City of Albuquerque

March 16, 1995

RE: DRAINAGE PLAN FOR DALE SEYMOUR 4TH NW & CLAREMONT NW
(H14-D79) ENGINEER'S STAMP DATED 3/9/95.

PROPOSED BUILDING SITE  
FOR  
DALE REYNOLDS  
(4TH STREET H.W. & CLAREMONT H.W.)  
ALBUQUERQUE, NEW MEXICO  
MARCH, 1995

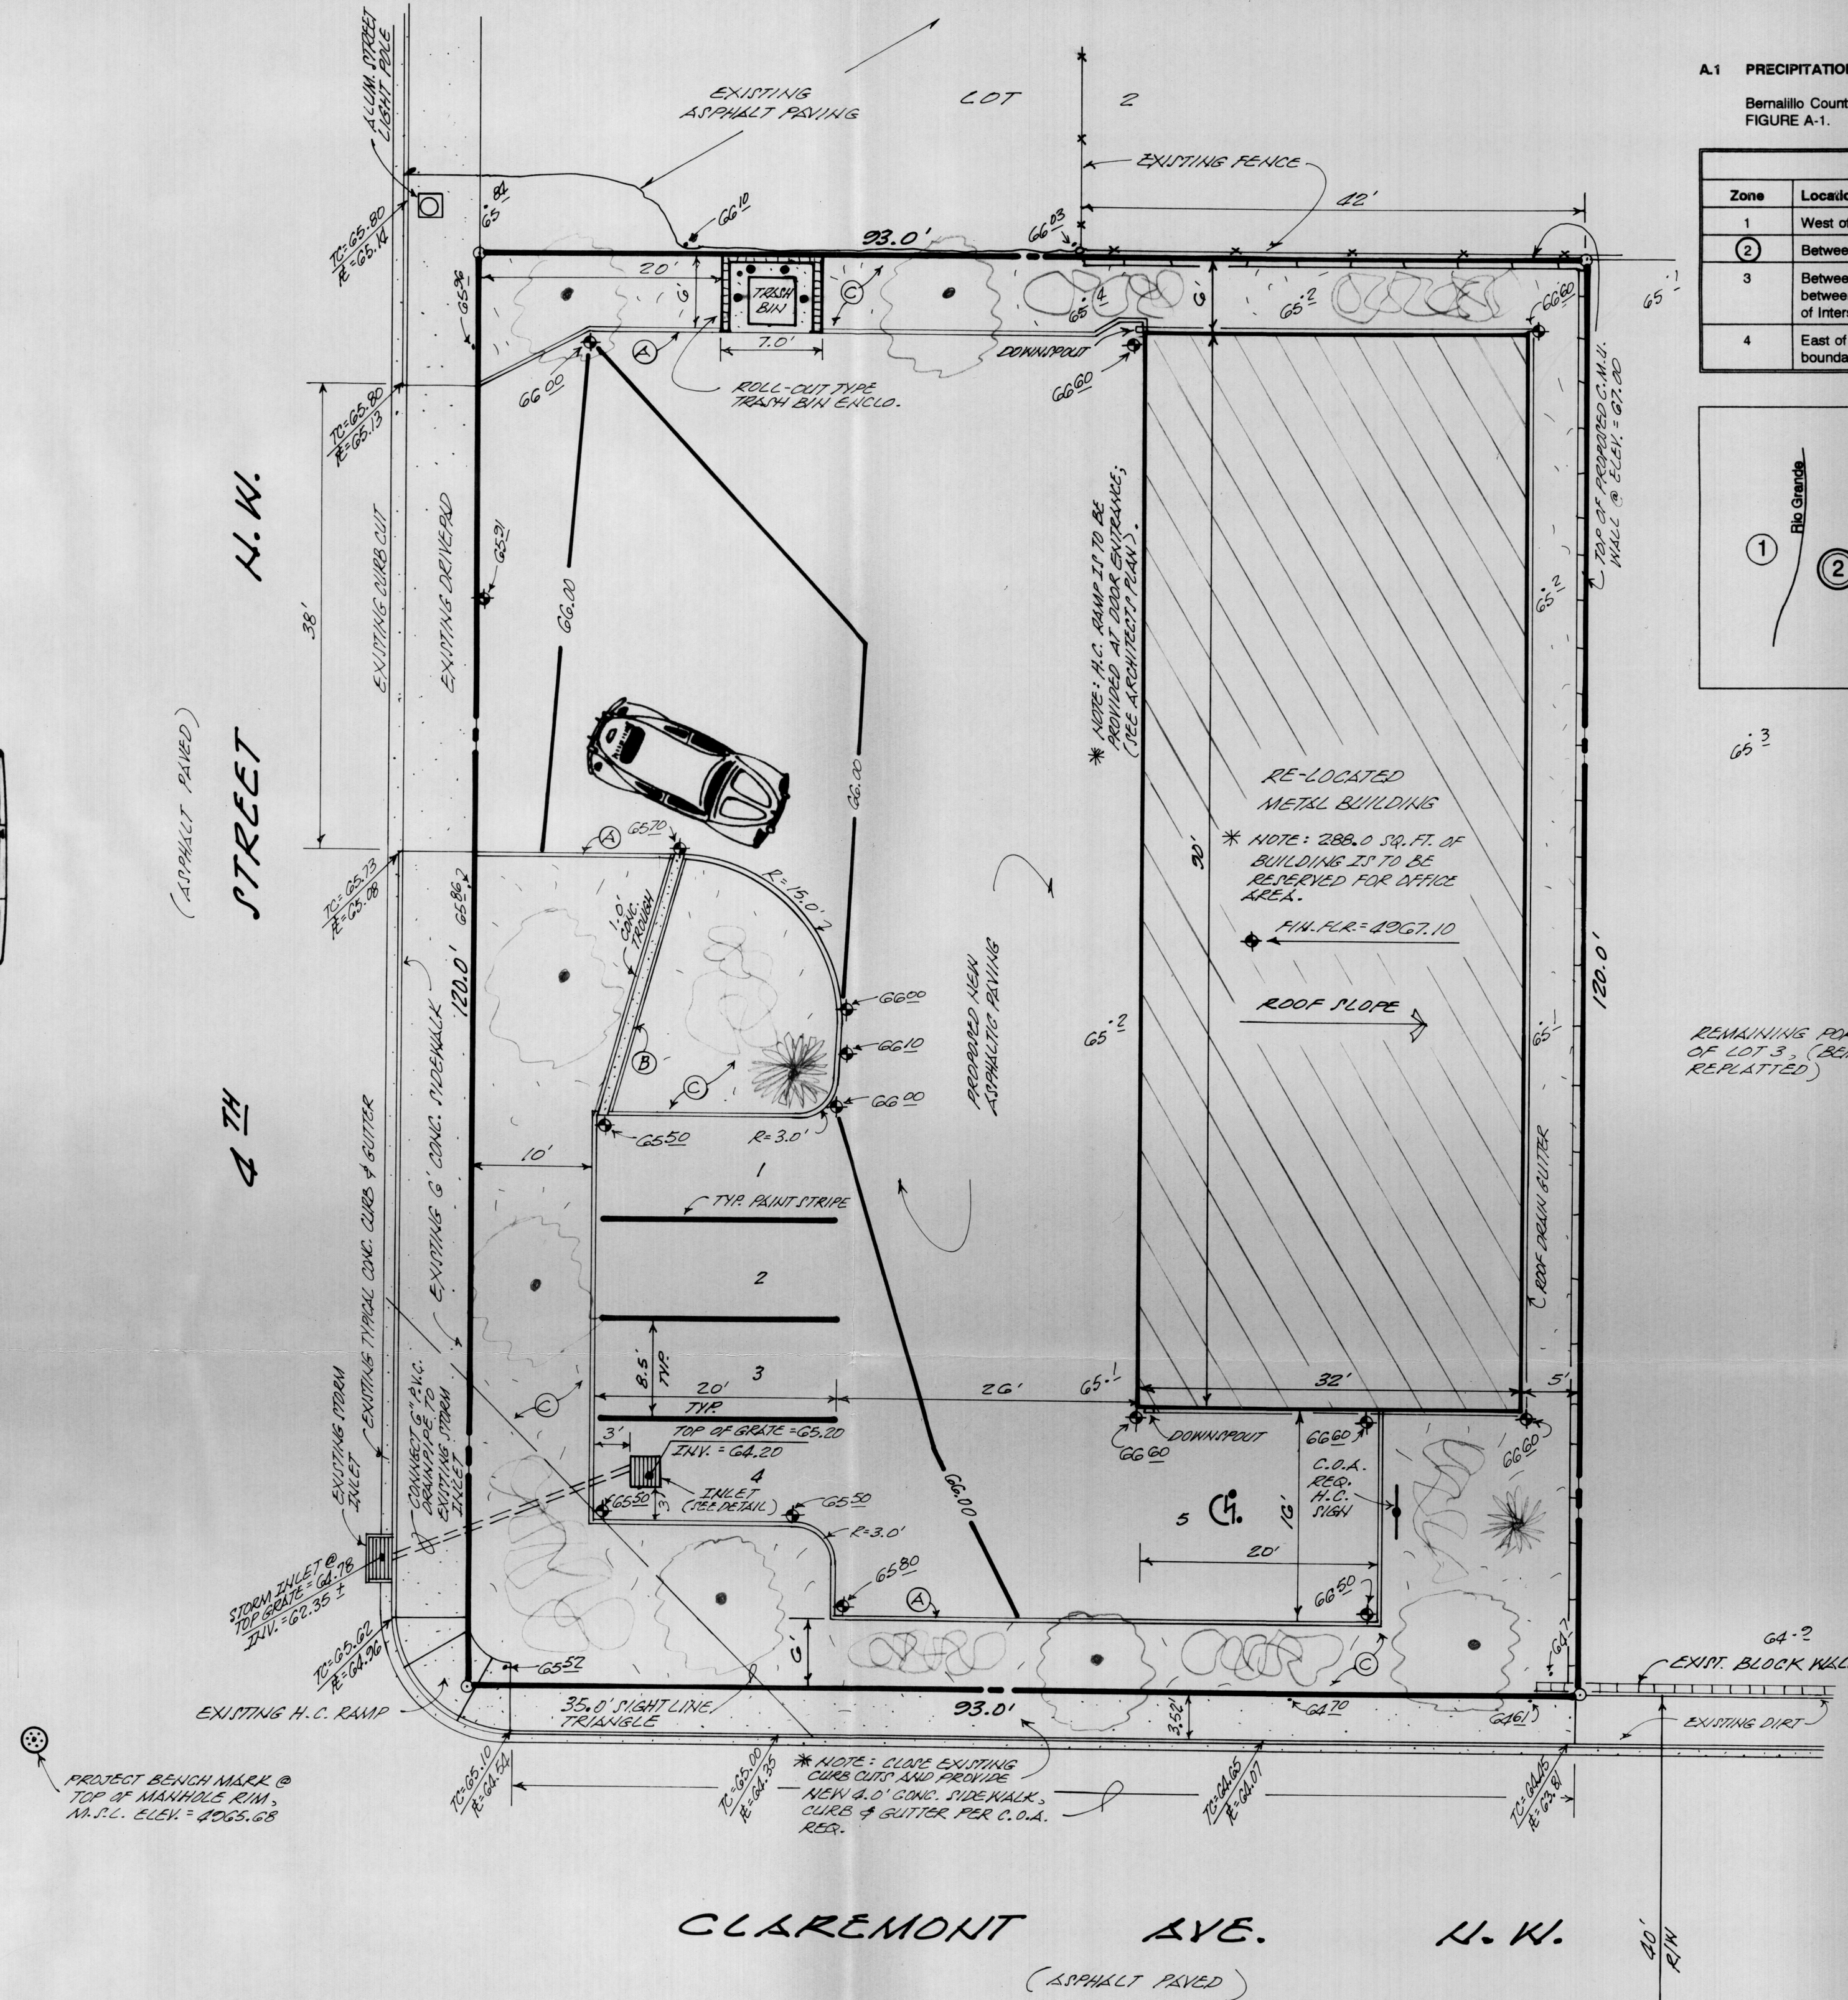
1. Six notes from the S.O. 19 format.
2. Sign-off block from the S.O. 19 format.
